EPC STORMWATER REVIEW COMMENTS
IN ORANGE BOXES WITH BLACK TEXT

GUNTZELMAN PORCELAIN PINES SUBDIVISION

GRADING AND EROSION CONTROL PLAN

COUNTY OF EL PASO, STATE OF COLORADO
FEBRUARY 2023

GRADING & EROSION CONTROL DETAILS

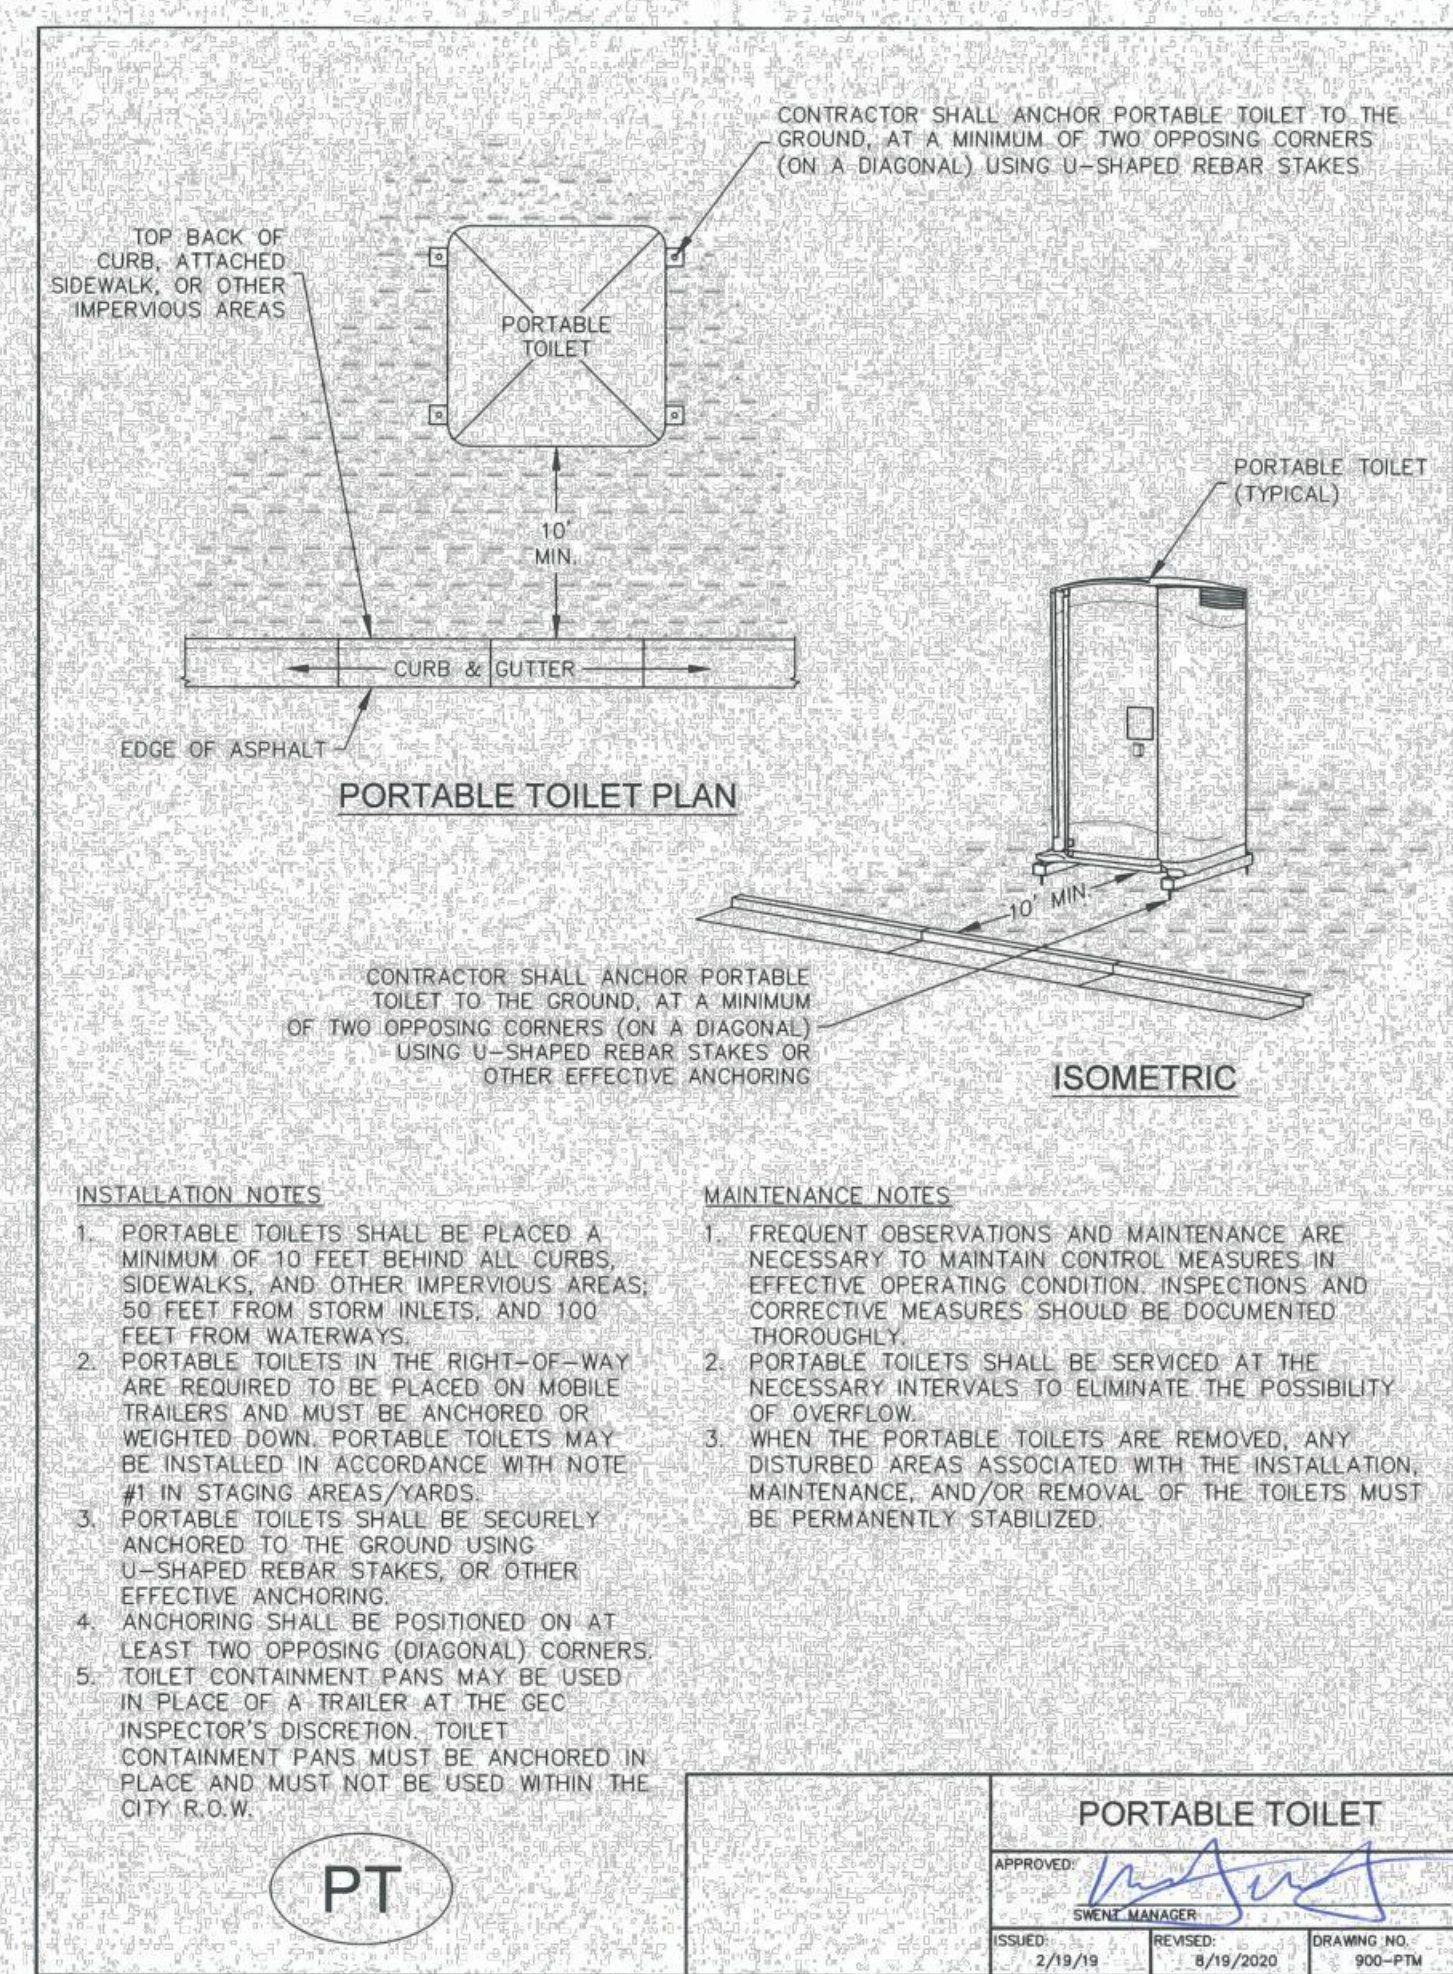
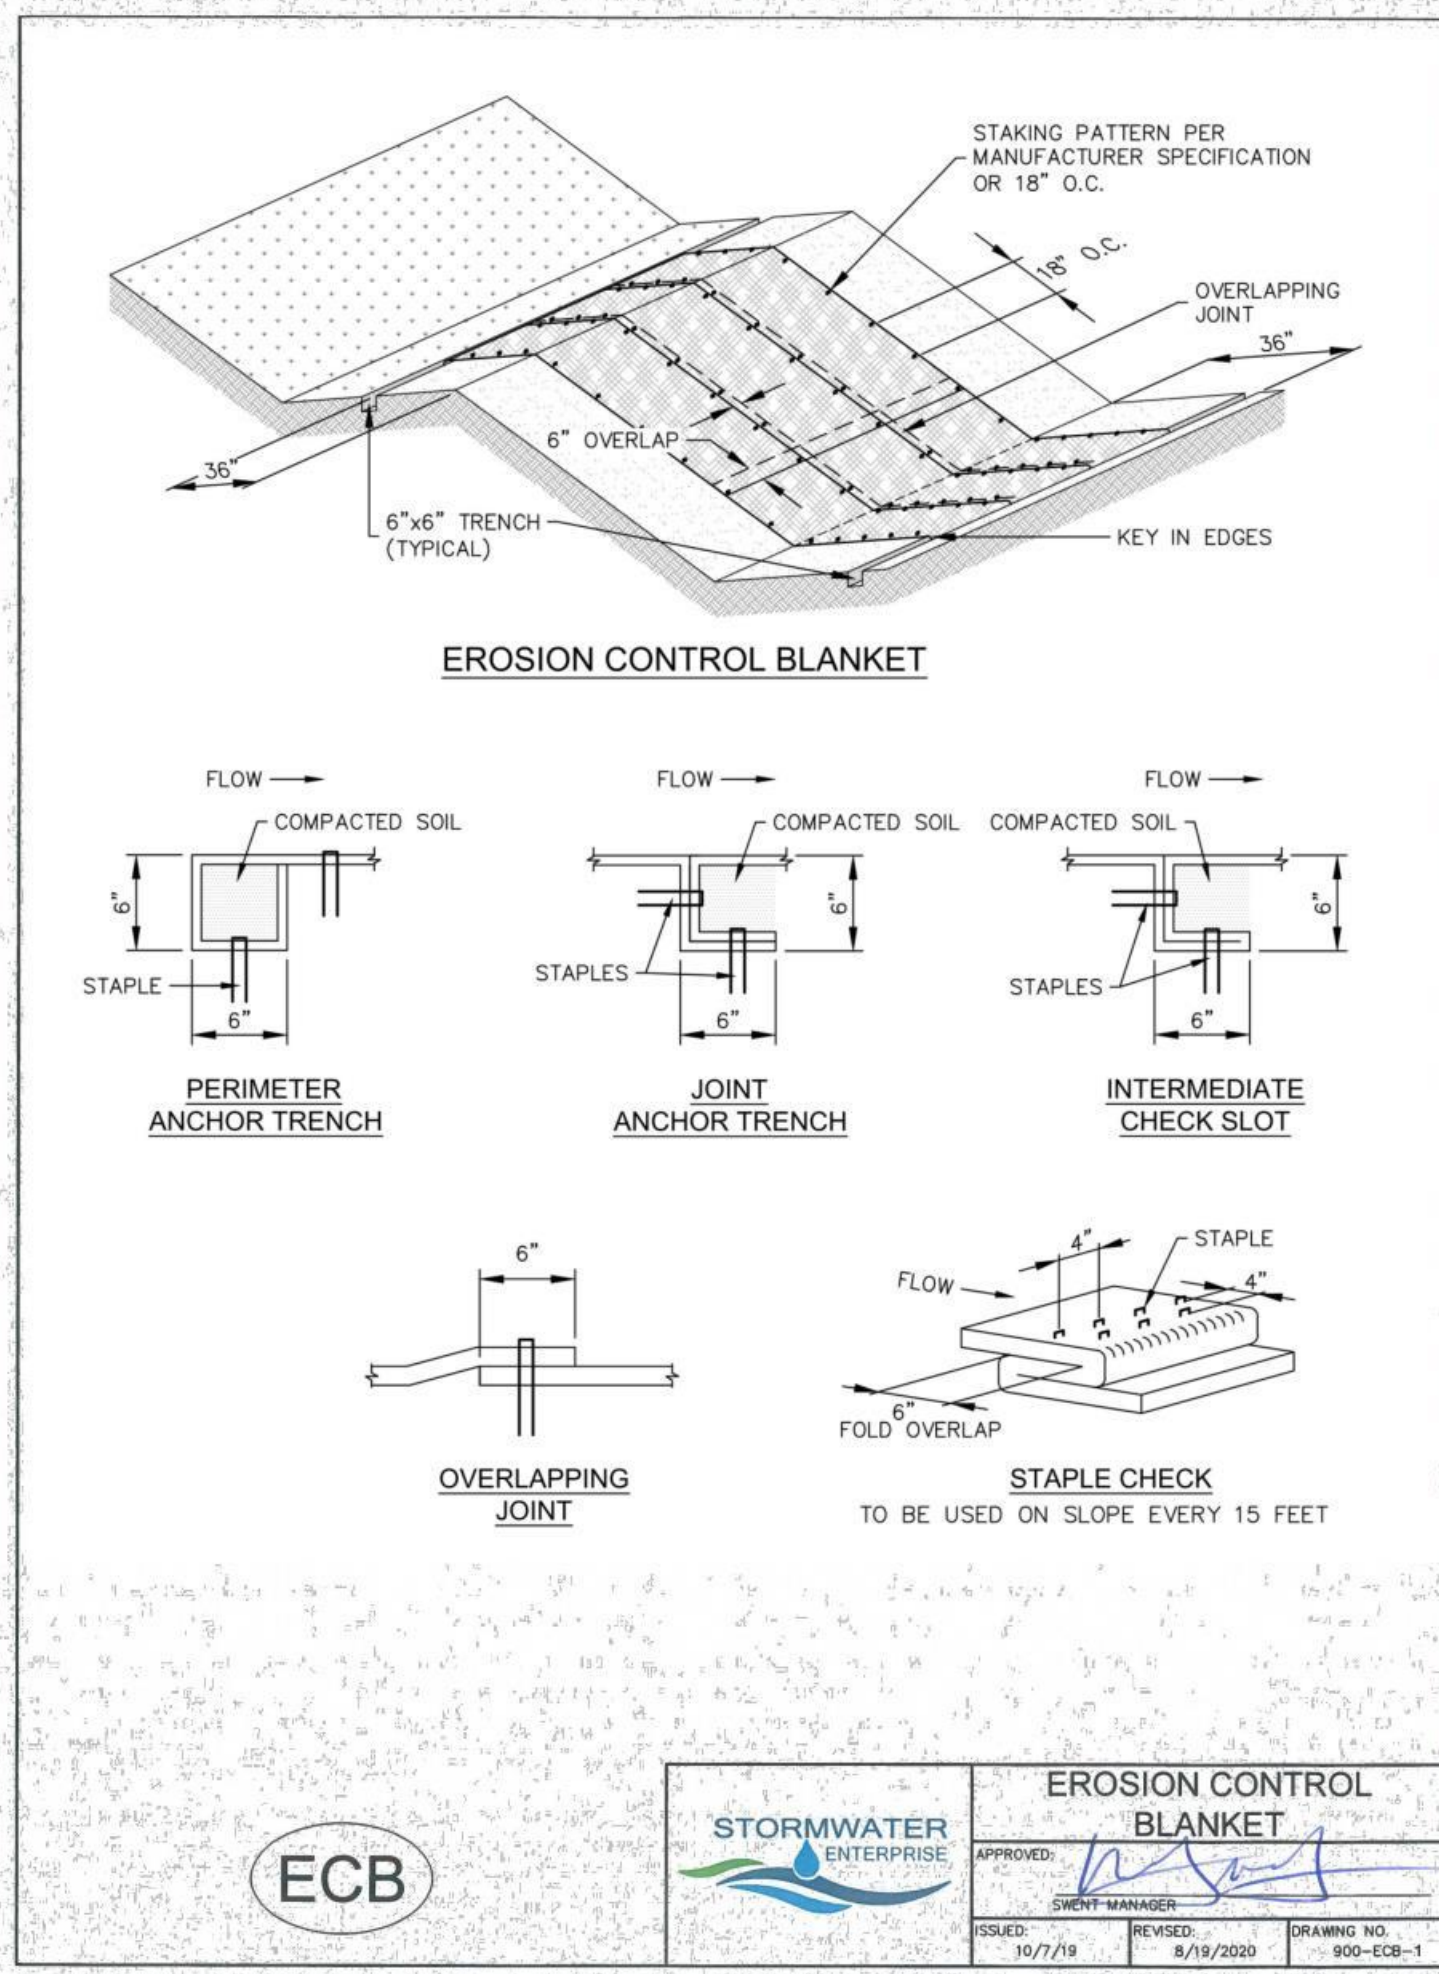
expand to fill white space so that notes are legible when printed.
